Planning (Listed Buildings and Conservation Areas) Act 1990 (as amended)

Application No: AB/125/20/L
Site Address: 19 Maltravers Street Arundel BN18 9AP
Description of works: Listed building consent for a single storey rear extension and alteration to existing kitchen roof.

Thank you for your internet representation made on 2nd January 2021 which has been recorded as no objection with the comments as follows:

19 Maltravers Street, Floorplan

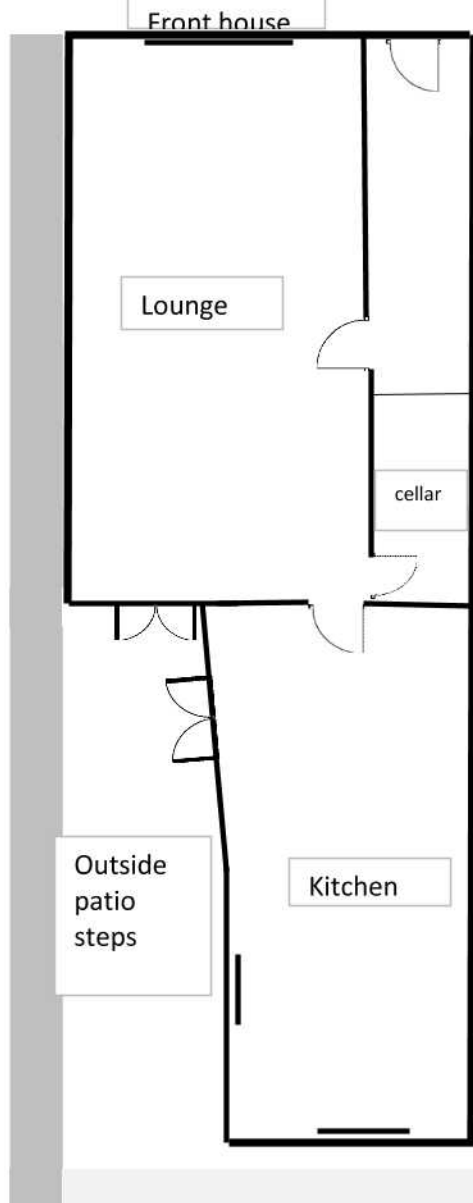
The Panel's remit does not include an assessment of the effect of the proposal on the heritage significance of the individual building. However, it is suggested that far more detailed plans are required in order that the Council can make a proper assessment of the impact. For instance, no precise details are provided to indicate how the junction between the facade of the extension and its flat roof will be treated eg bargeboard or parapet. The finishes, materials and detailing chosen for this feature and the extension overall need to be high quality, otherwise there will be detriment to the heritage significance of the building.

Elevation view 19 Maltravers Street, Arundel, BN18 9AP

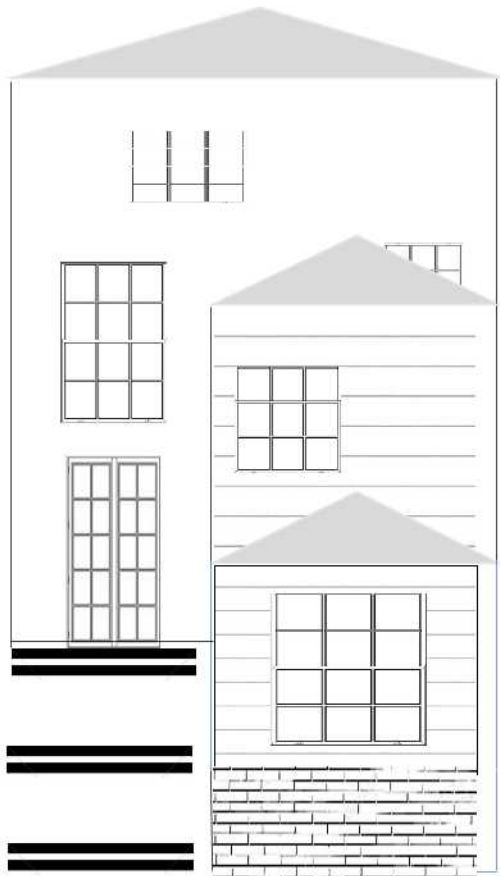
The proposed extension is modest in scale and located on the rear elevation of the building with no public views of it and limited ones from nearby properties. As such there will be a neutral effect on the character or appearance of the conservation area.
